About the application

Application number: 2024/90339	
What is the application for?:	Erection of part two storey and part single storey front, side and rear extensio
Address of the site or building:	19, Cheviot Way, Upper Hopton, Mirfield, WF14 8HW
Postcode:	WF14 8HW

PROPOSED BLOCK PLAN
1:500

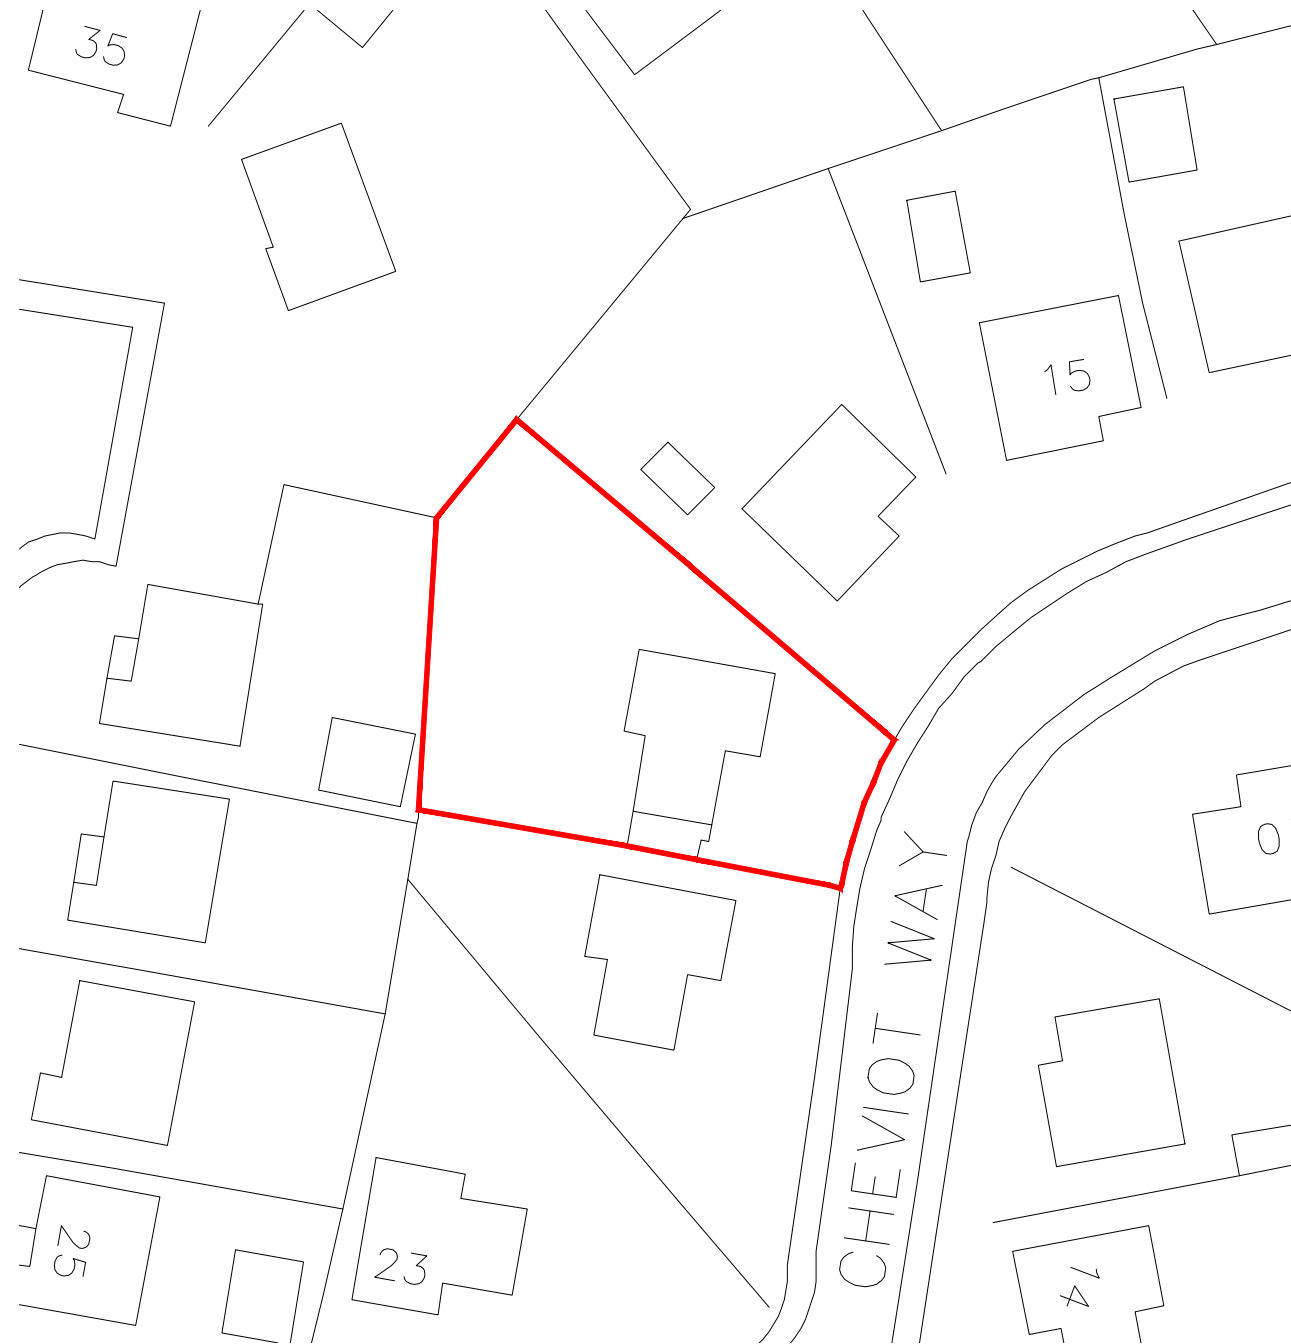
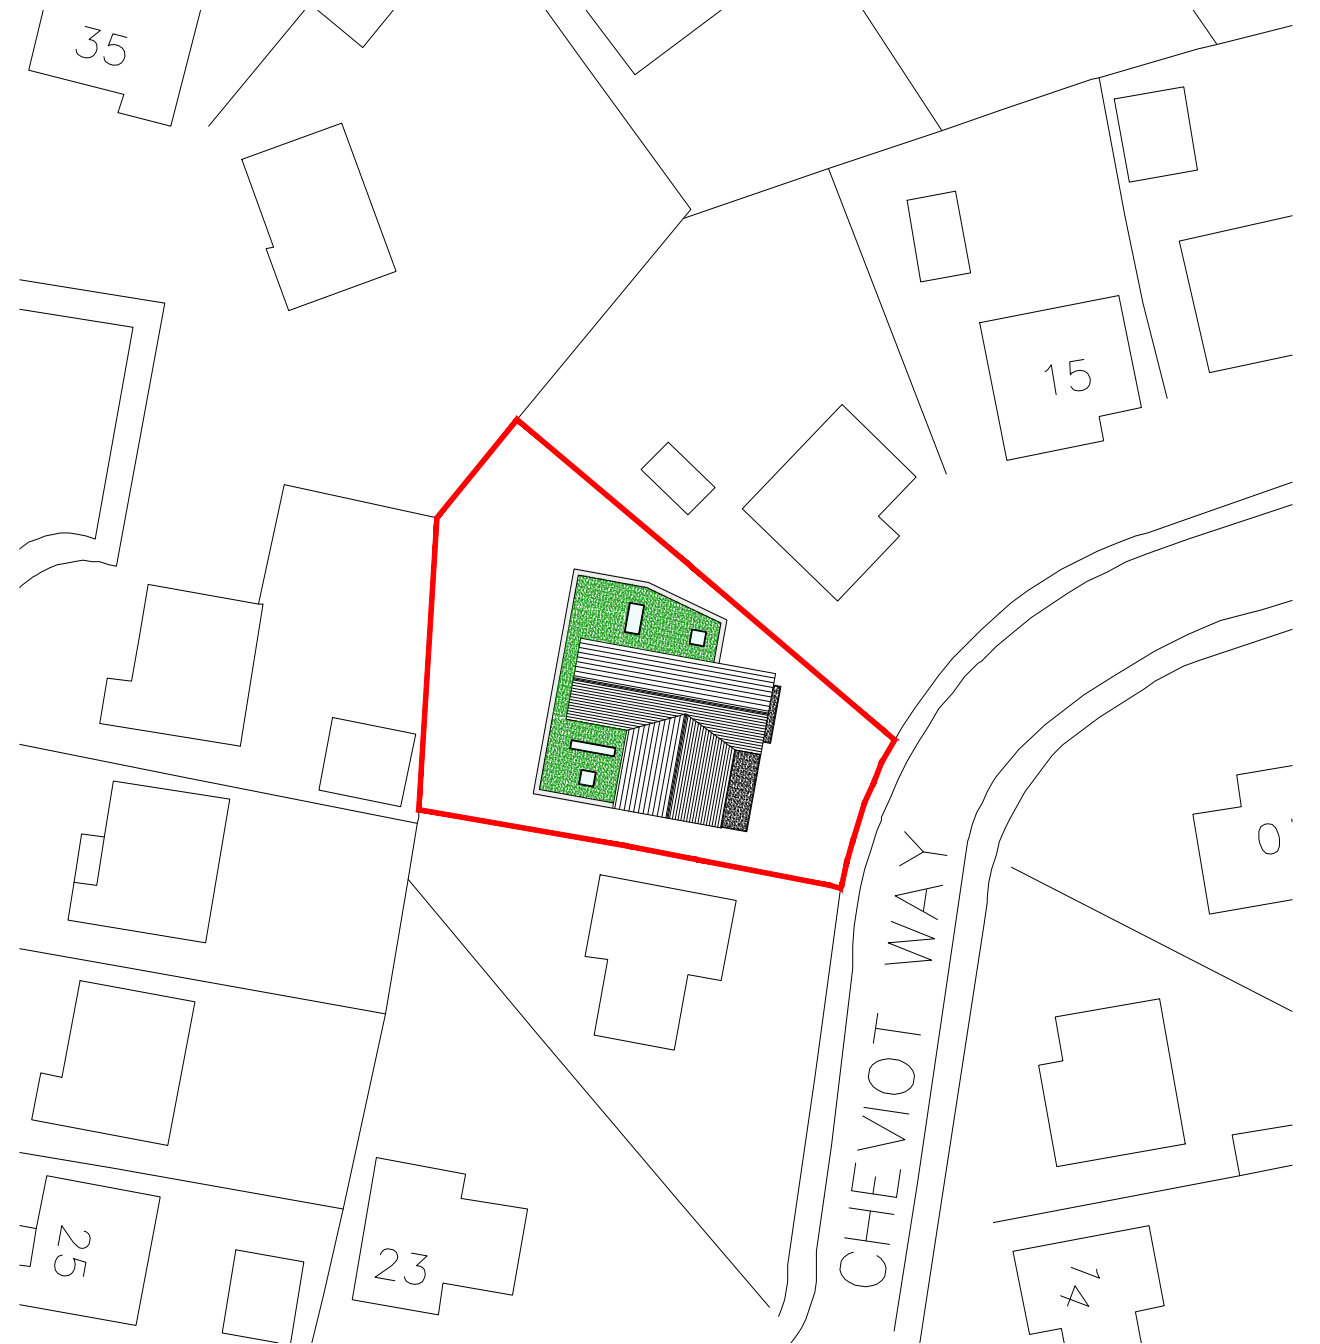
Substantially increased size of an already large property. Over developing the site, leaving little outside space and the increased building size leaving small gap to the boarder, being out of scale with the size of the site and surrounding properties.
